**KIRKLEES METROPOLITAN COUNCIL
INVESTMENT & REGENERATION SERVICE**

**DELEGATED DECISION TO DETERMINE APPLICATIONS FOR
CONSENT, AGREEMENT OR APPROVAL REQUIRED BY CONDITION**

Reference No:	2026/44/91034/W
Site Address:	University of Huddersfield, Queensgate, Huddersfield, HD1 3DH
Description:	Discharge of details reserved by conditions 3, 4, 5, 6 (drainage), 7 (Phase II Site Investigation) on previous permission 2026/90009 for provision of new landscaping scheme on the site of the former faith centre building together with extended delivery area and turning circle and associated works
Recommending Officer:	John Holmes

DECISION – APPROVE DISCHARGE OF CONDITIONS

Project - Originator - Zone - Level - Type - Role - Number  
700324-HEX-XX-XX-D-C-9200

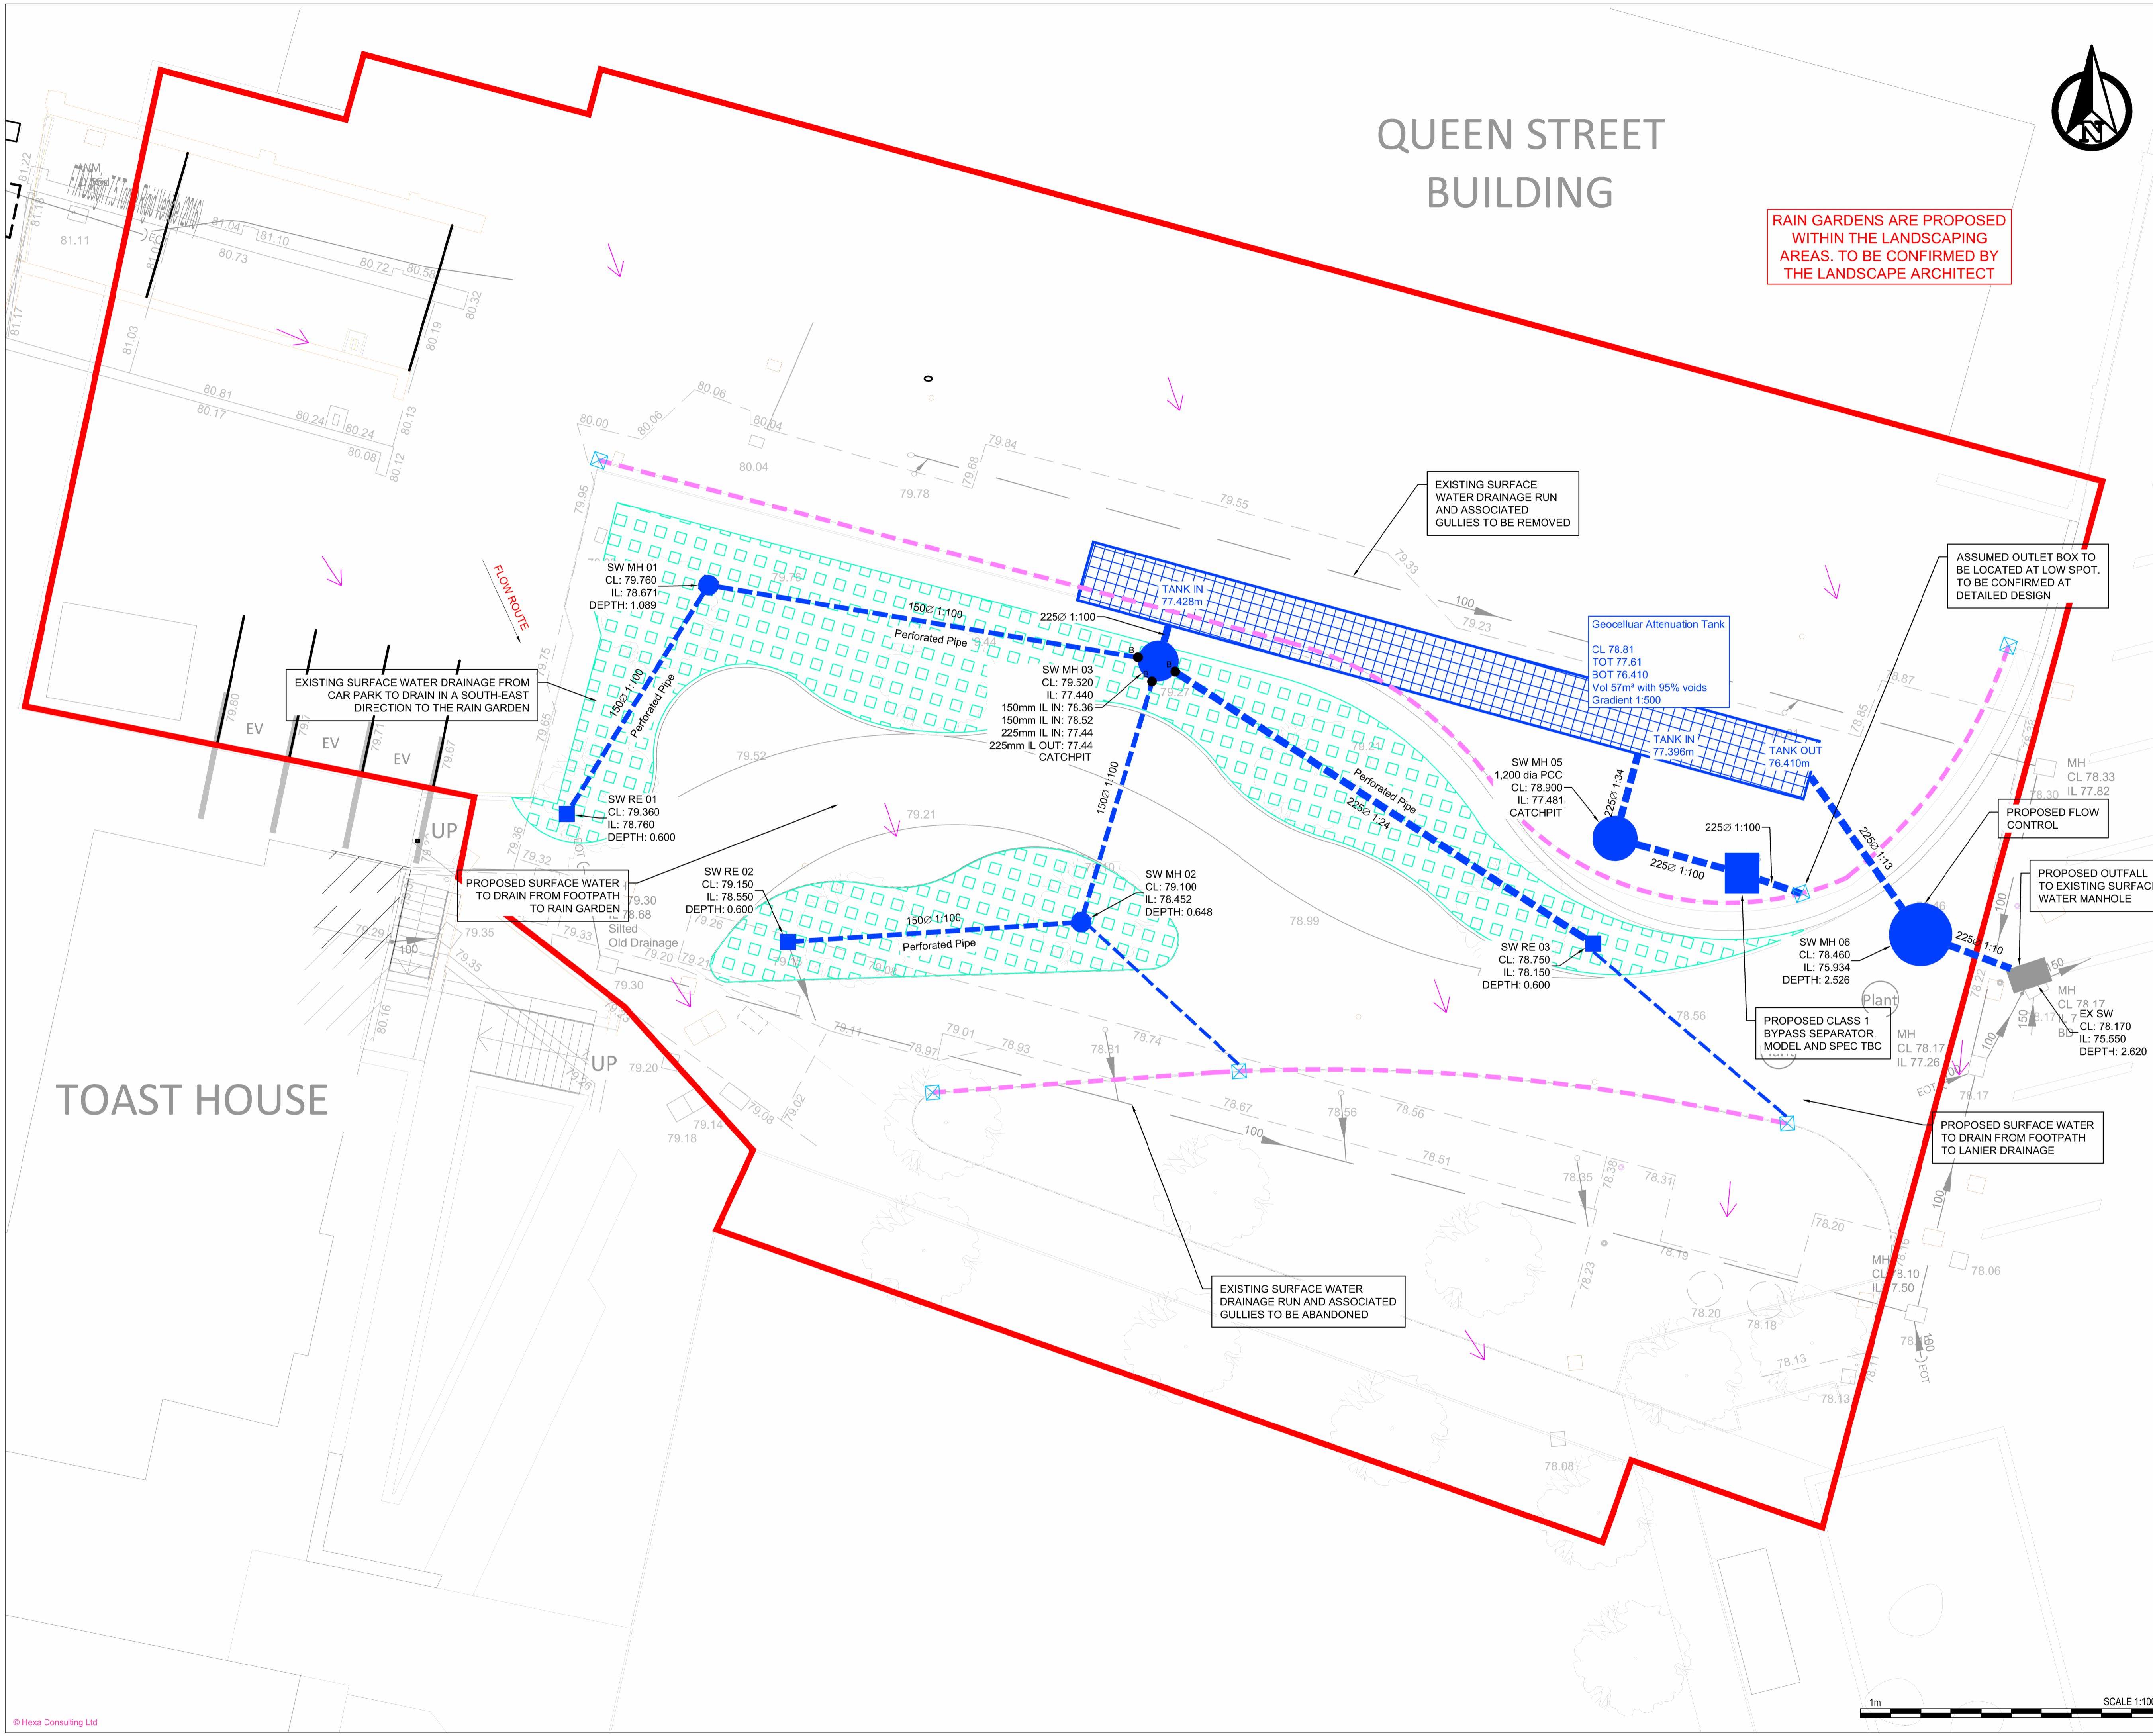
In relation to condition no.3 they stated that the drainage drawing did not indicate the design parameters of the proposed flow control device (design flow rate, design head, outlet diameter). In addition, they stated that no details of the attenuation tank dimensions/depth were shown together with the means of access into the tank for inspection and maintenance compliant with CDM Regulations together with a Maintenance Plan for the tank & flow control device. They confirmed that the flow control device and tank details needed to be shown to ensure the correct device / tank is installed.

In relation to condition no.6 they advised that the model of the proposed oil separator needed to be provided.

Following on from this, the applicant submitted an updated plan (drawing 700324-HEX-XX-XX-D-C-9200, Drainage Plan, Rev P02 dated 19/02/26 including additional annotations dated 16/03/2026 received 13th May 2026).

On the basis of this updated drawing the Lead Local Flood Authority confirmed, in an email dated 13th May, they had no objection to the discharge of conditions 3 & 6 as the required information had now been provided.
